Subject: Care Home at Pound Place, Roundstone Lane, Angmering Application no. A51/18/PL

My colleague Murray Chrystal has sent you a set of updated amended plans reducing the scheme in a number of different ways, together with a reduction in bedrooms, from 71 to 64. The purpose of this email is to highlight the nature of these changes in order to assist your consideration of the application.

**TREE PROTECTION PLAN**

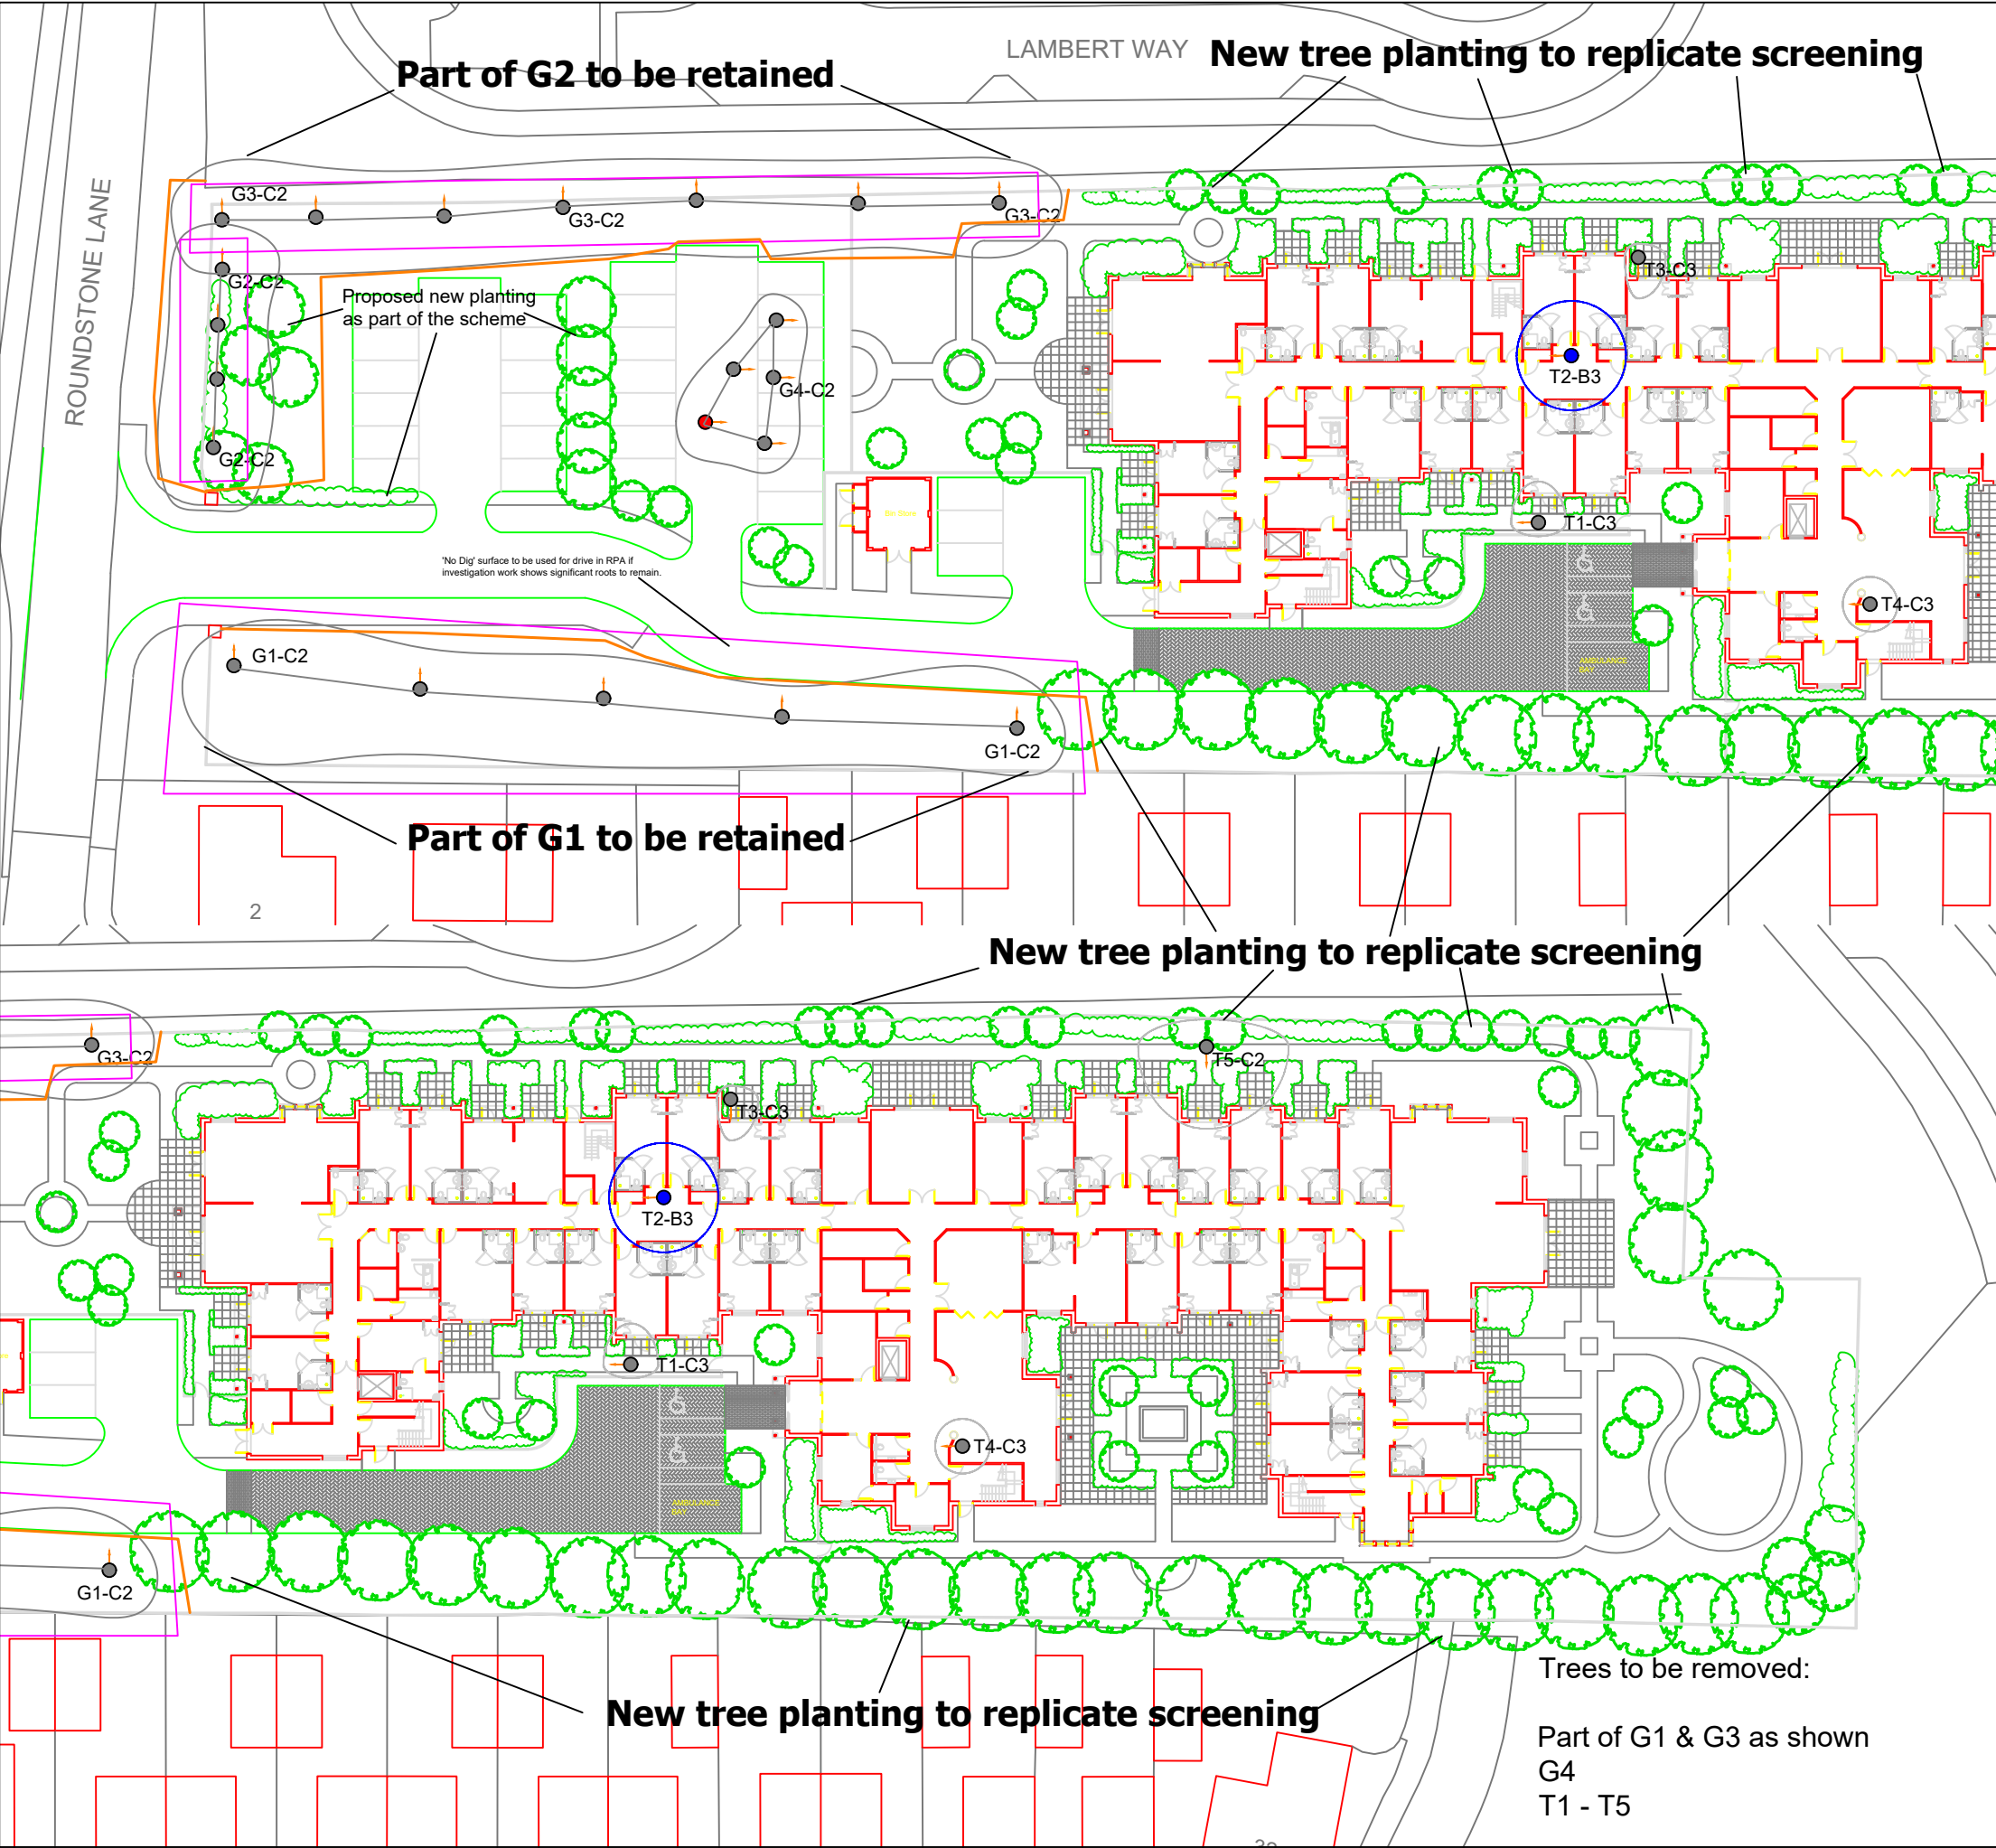
In respect of trees, you may be aware that we carried out a public consultation exercise with neighbouring residents and the Parish Council. At present the site is characterised by a large number of conifer trees that lie at the rear of a number of existing residential properties to the south. The overall consensus was that it was best to remove these trees and replaced them with more appropriate specimens that are compatible with the residential gardens to the south west, whilst also creating an attractive screen and buffer to the proposed care home. The applicant remains flexible as to how these trees are treated and or replaced. This can either be discussed further with you during the course of this application or be dealt with by way of a planning condition.

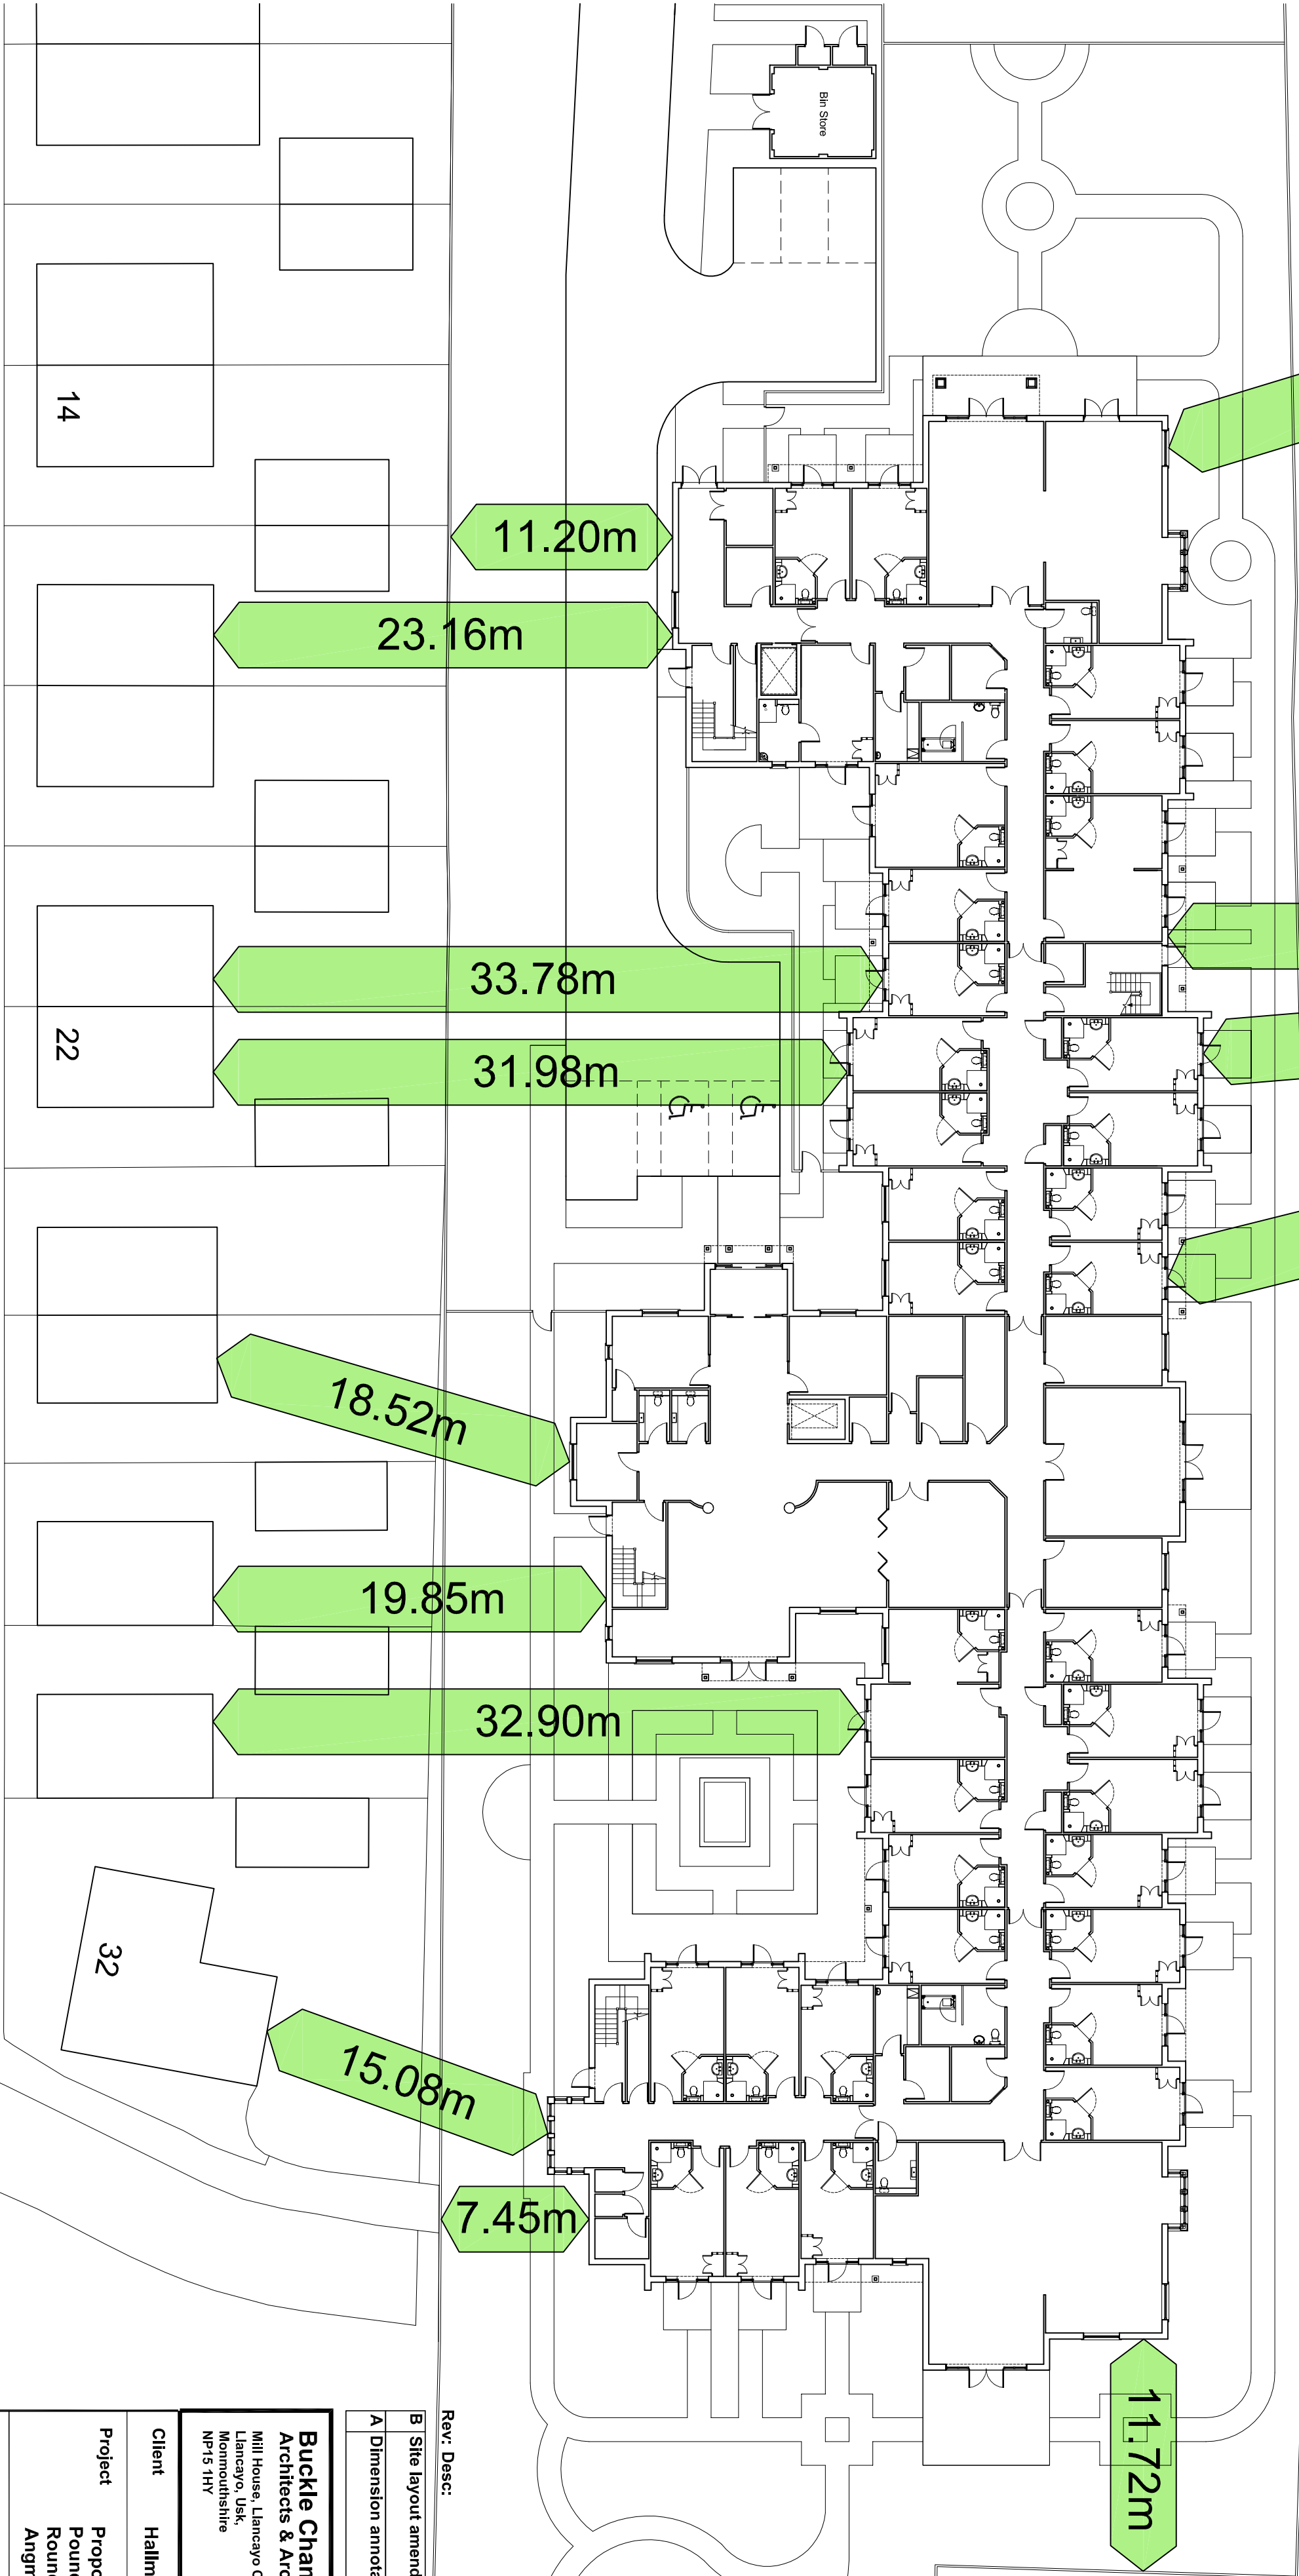
These amendments should allow the building to set more comfortably with the neighbouring homes as well as within the site itself. In this regard, please note that the footprint of the building has also been reduced on the southern side as evident from the site layout plan. This too allows the building to sit more comfortably within the site and improve upon relationships with neighbouring properties to south.
